## RE: 356 State St., BP# 2016-00971 plan review comments - jmb@portlandmaine.gov

**Subject:** 356 State St., BP# 2016-00971 plan review comments

Hi Erin and Deen, I have commenced the review of this permit application and will need some additional information as listed below:

SHEET NUMBER:  
**QF100**

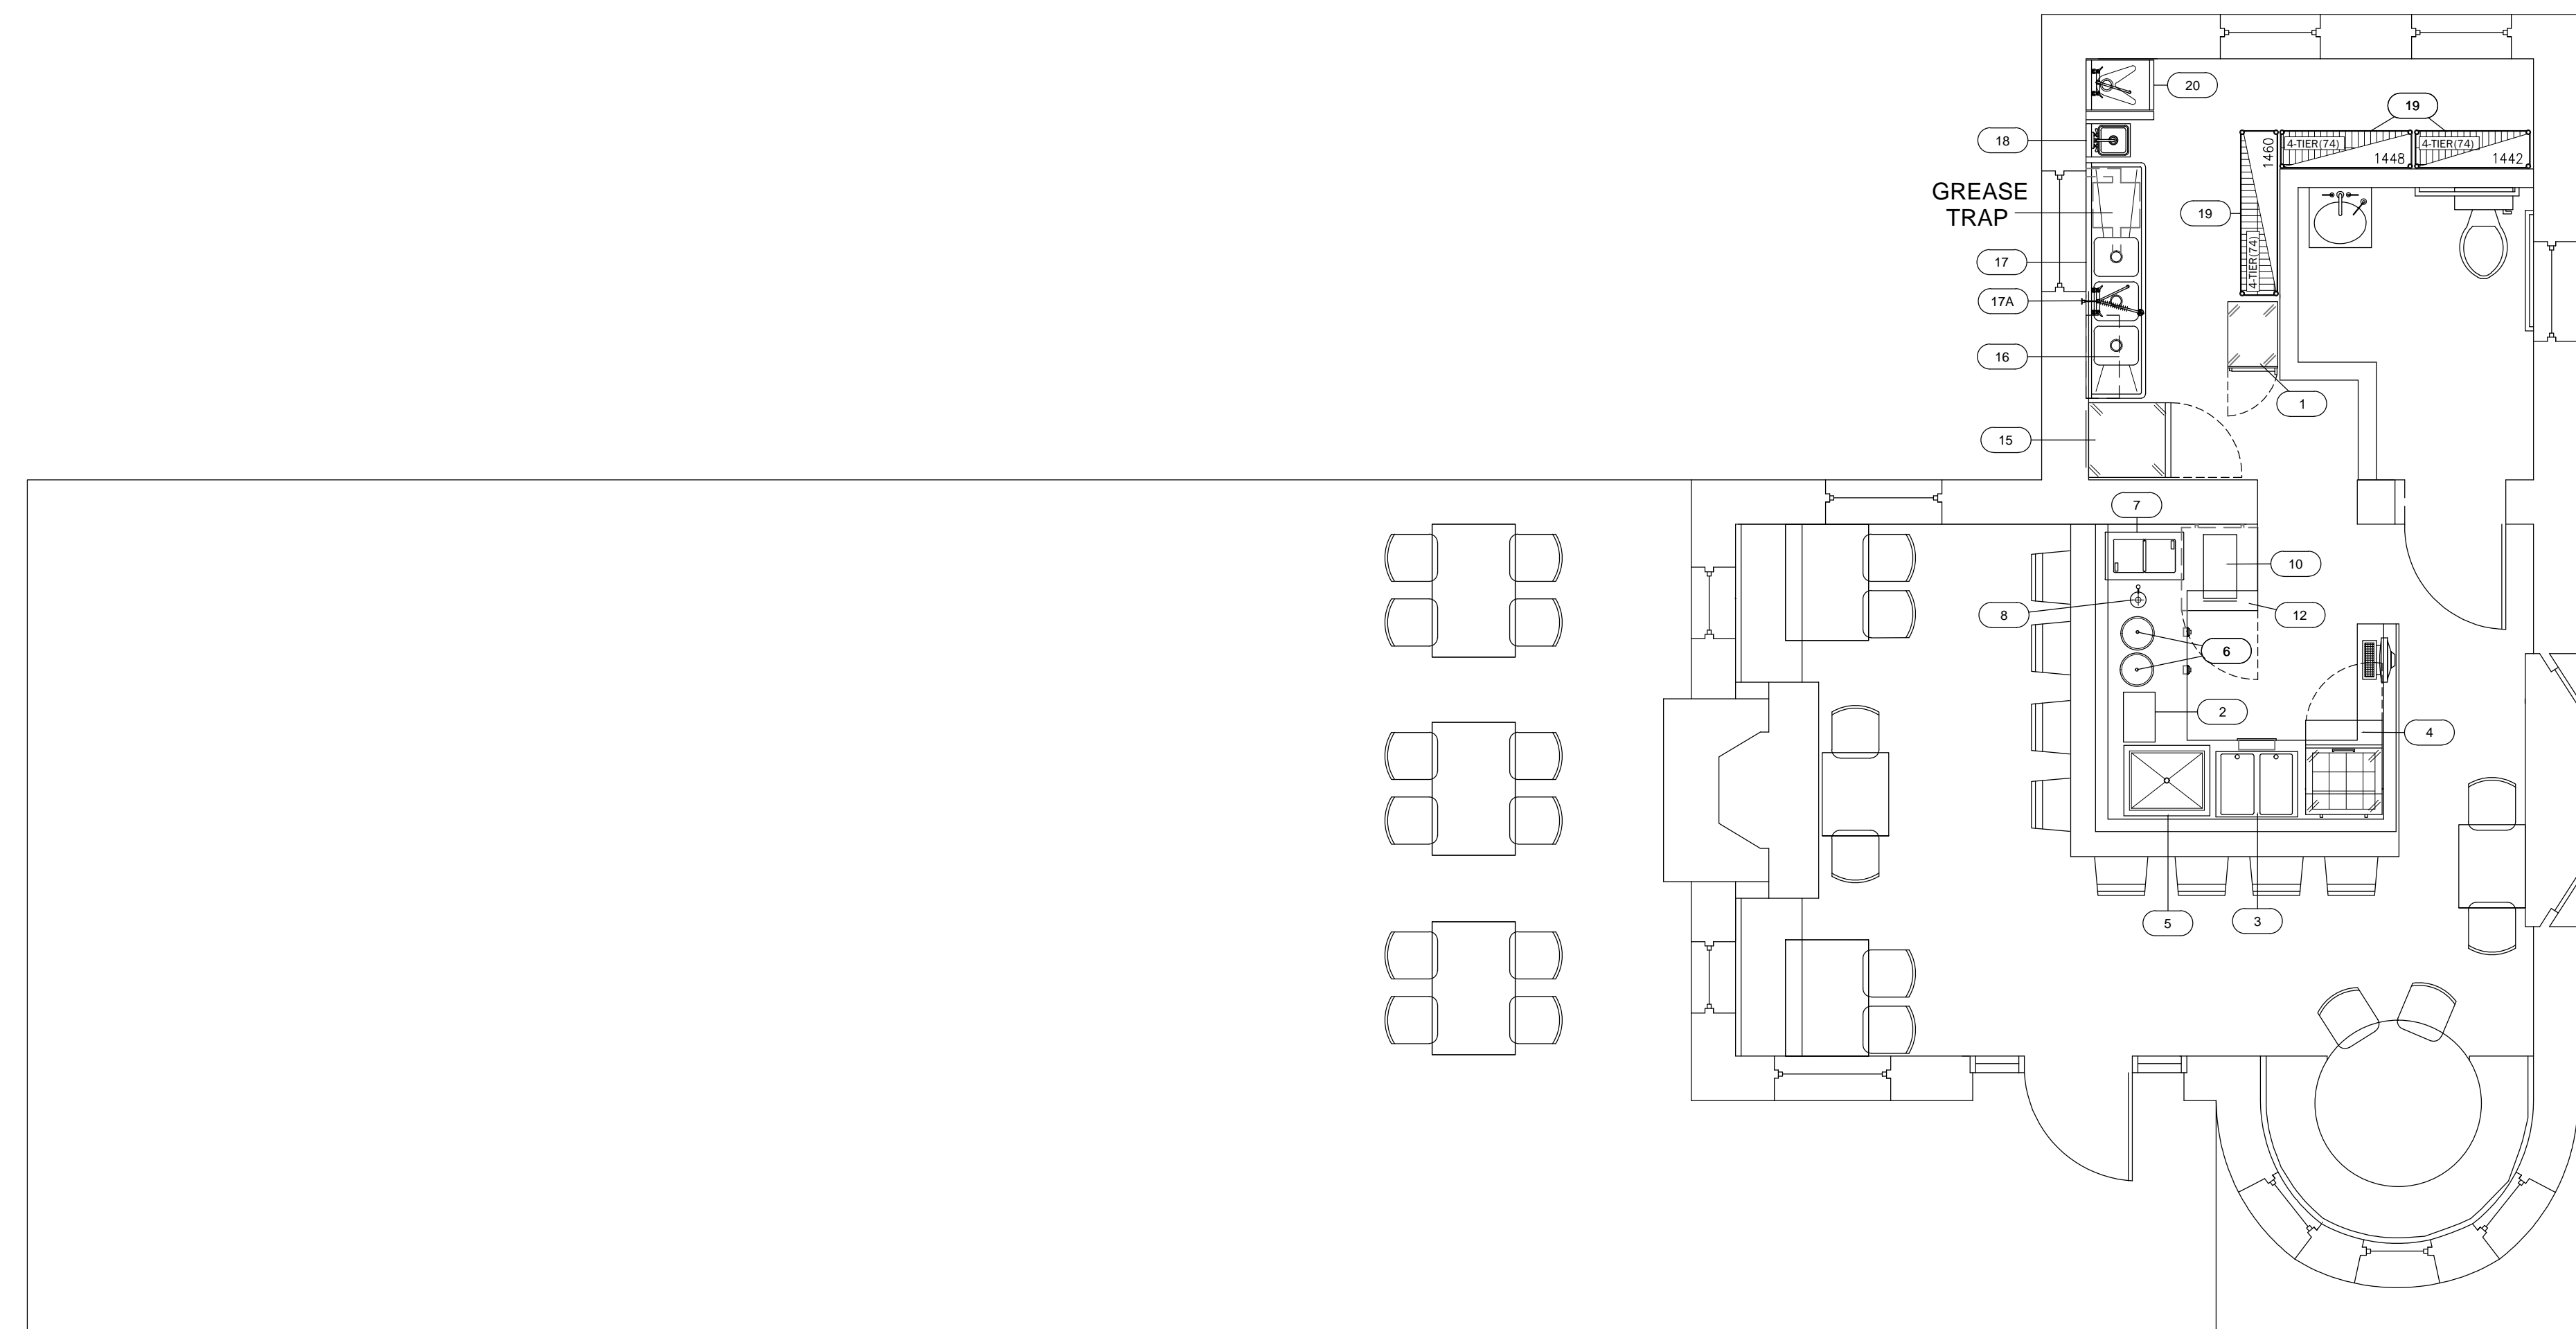
1. A scope of work detailing the specific construction from rough framing to finish surfaces for the fit up of this space. Please provide existing and proposed plans.
2. An updated food service equipment and fixture plan. If preparing salads and sandwiches at the bar a hand wash sink may be required. Verify with the Public Health inspectors.
3. A separate floor plan with the items we discussed in our meeting on April 4, occupant load calculation, ADA seating compliance details, aisle width minimum dimensions (the 2 seats at the bay window look to be encroaching), total number of outside seats, bar section with dimensions. The bar area seems larger than I recall, is this the most updated updated? Let me know if you have any questions. Thanks

Jeanie, Attached is the final design for Tiqa Café. It has changed since we submitted for the permit. I have reached out to Public Works for an existing plan. The new scope of work: Demo: We will be demoing the existing counter/bar in the space. Disconnecting power at existing bar. No other finished of the existing building will be removed. Construction: Constructing a bar with granite and stainless finished. There will be a 3-bay sink, grease trap, and hand wash sink located at the bar – it will no longer be in the bathroom. Electrical will be run to the bar for power of fridges and heating elements. The plans attached provide the updated food service equipment and fixture plan, sections, and dimensions. Would you like me to bring in a flash drive in with the files? Thanks, Erin
